## Application for a Non-Material Amendment Following a Grant of Planning Permission

Side two storey extension over & replacing existing garage, plus single storey rear full width extension.

20/00361/FU

Seeking amendment from current approved hipped roof to gable ended, to two storey section proposed.

PROPOSED ROOF PLAN
1/100

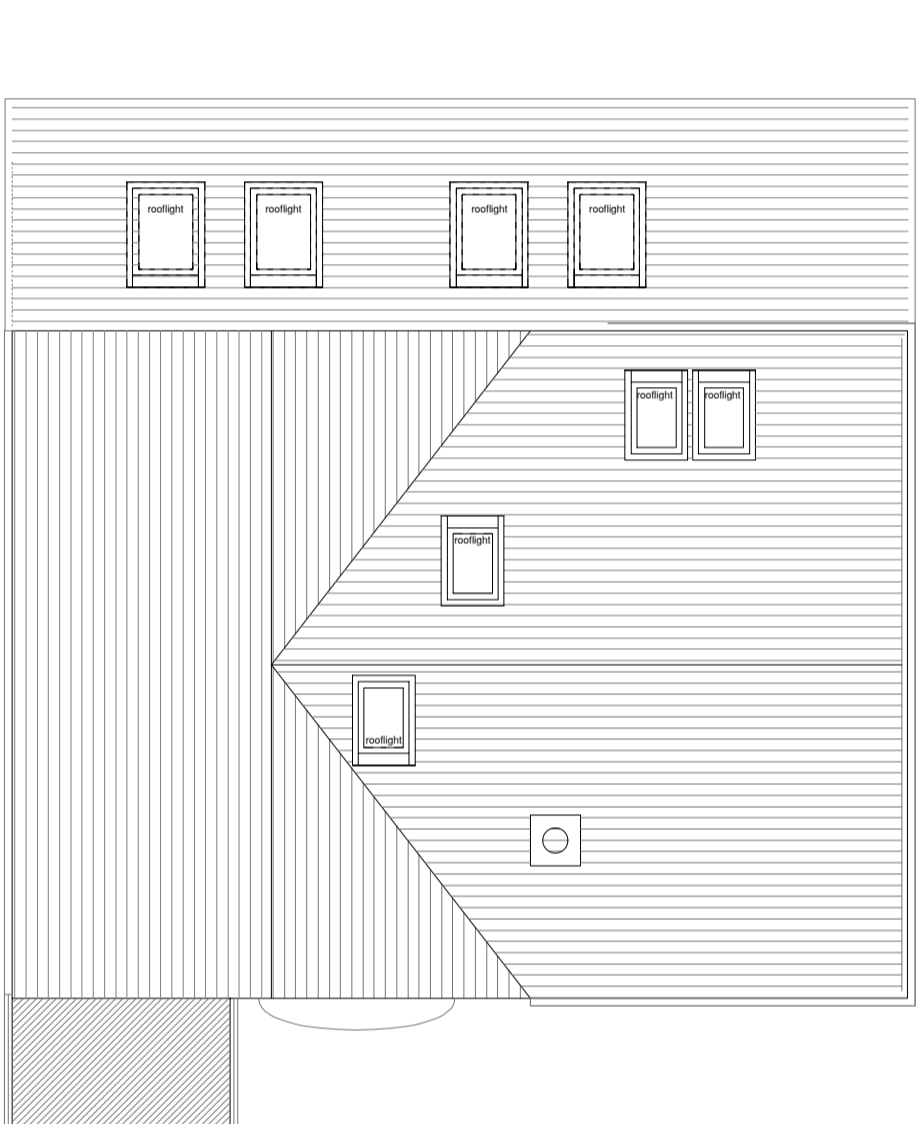
Both on grounds of design and buildability, review of street scene offers guidance historically of gable extensions.
